November 29, 2023
Project No. T-8718

Subject: Response to City of Mercer Island Comments
3036 – 67th Avenue SE
Mercer Island, Washington

11/20/23
 JOB NUMBER:
22-042
 SHEET NAME:
SP-01
 SHT **5** OF **9**

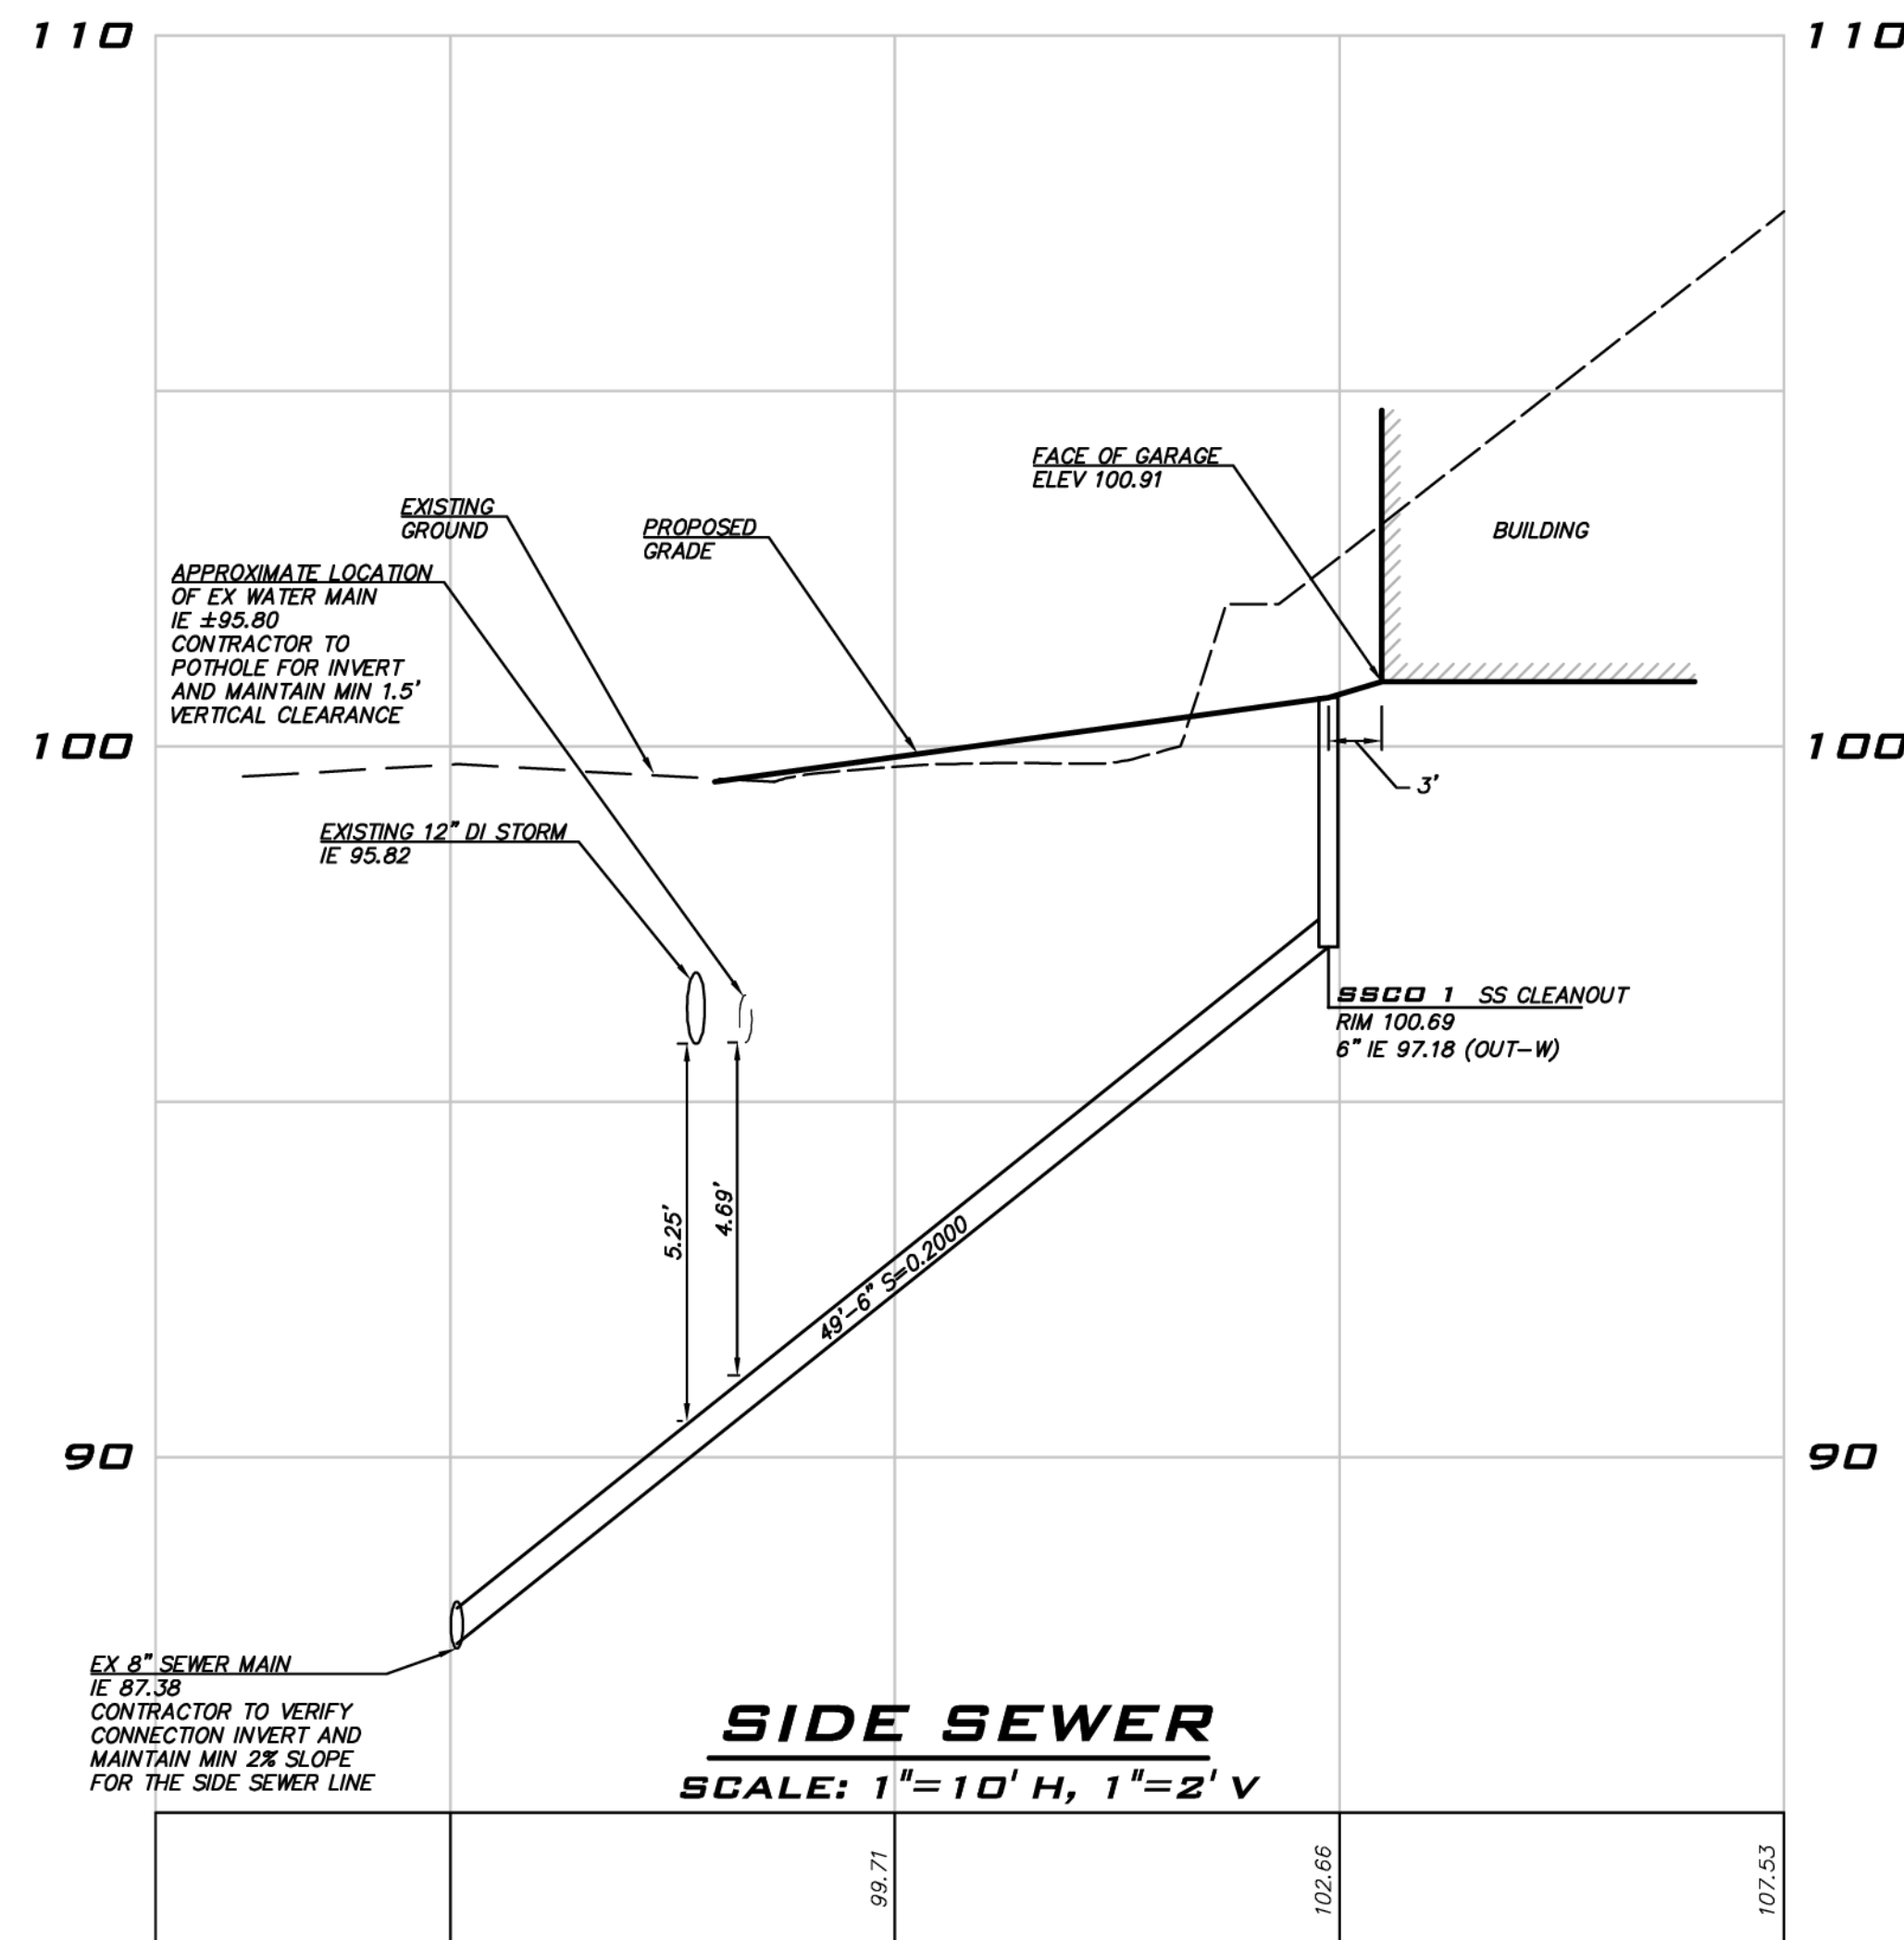
With the SUB5 plan set submission, please provide review letter from geotechnical engineer of record and updated statement of risk.

As requested, we have reviewed Sheets S-0.0 and S-0.1 prepared by Mulhern+Kulp dated November 27, 2023, Sheets A1.1, A2, A8, and D1 prepared by Architectural Innovations, P.S, dated November 27, 2023, and Sheets SP-01, TG-01, and DT-01 prepared by Atwell dated November 20, 2023. Based on our review, the project consists of developing the site with a new single-family residence, associated access, and utilities. The plans indicate the residence will be a three-story, wood-framed structure with an attached garage constructed at grade. An interceptor trench will be installed on the east side of the site with a bottom elevation of 95.70 feet.
